CITY OF PORTLAND, MAINE
HISTORIC PRESERVATION BOARD

June 21, 2013

Re: Storefront Alterations; 15 Exchange Street

117"

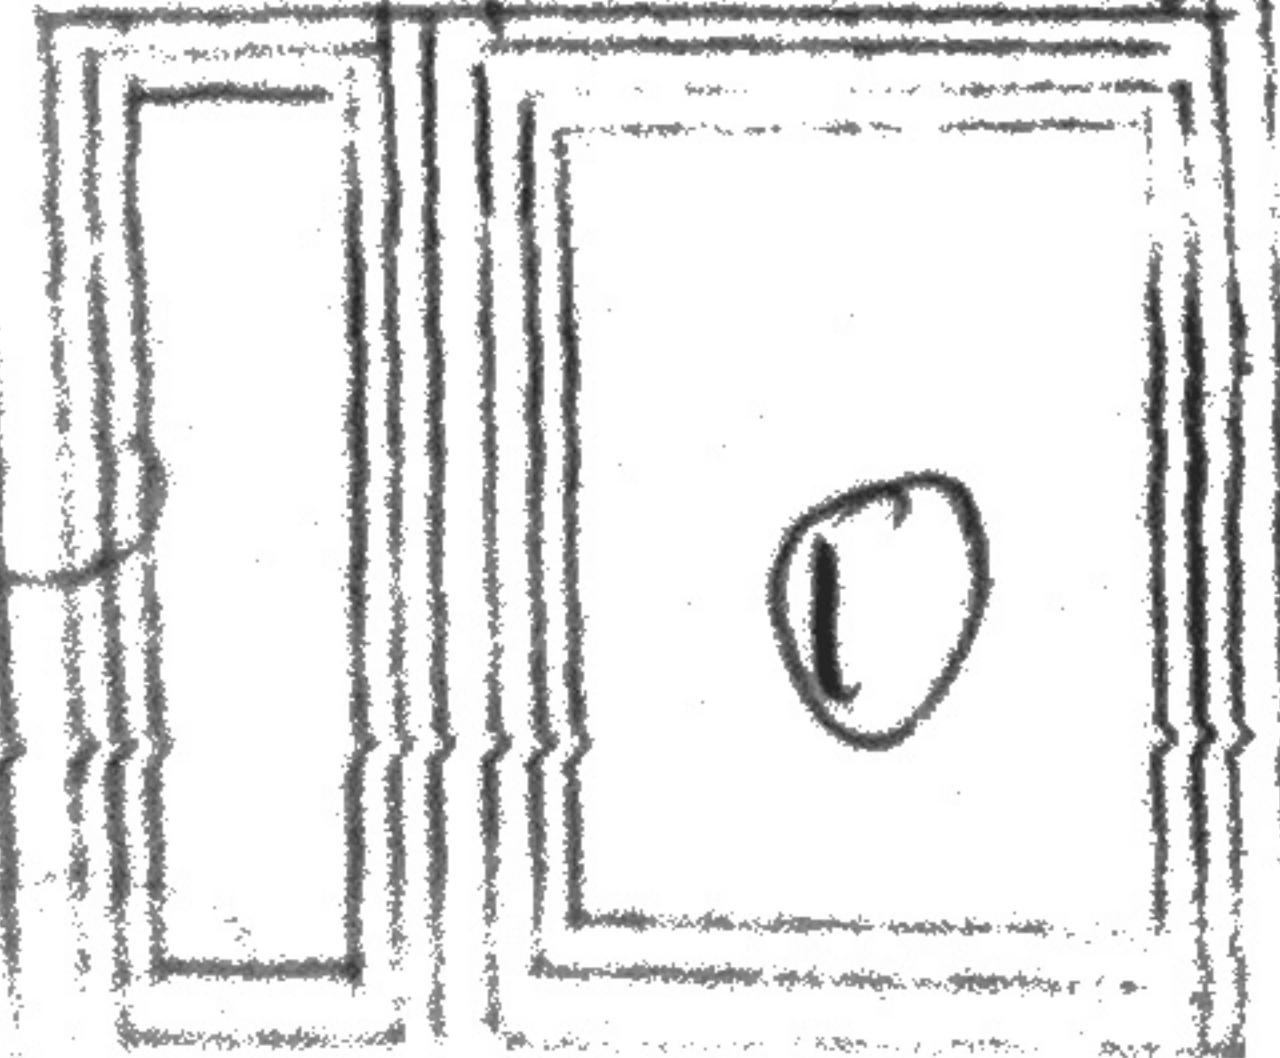
- All trim profiles and frame details to match details of remaining unaltered storefront bay.
- Final finish material and construction details of entrance threshold to be reviewed and approved by HP staff. (The Board recommends installation of granite or tile, consistent with threshold surface materials in the vicinity)
- Any additional lighting to be reviewed and approved by HP staff. Existing floodlights mounted on cast iron columns to be removed.
- Applicant to arrange for series of mid-construction inspections to ensure conformance with conditions and quality workmanship. (Call Rob Wiener, Preservation Compliance Coordinator, at 756-8023.)
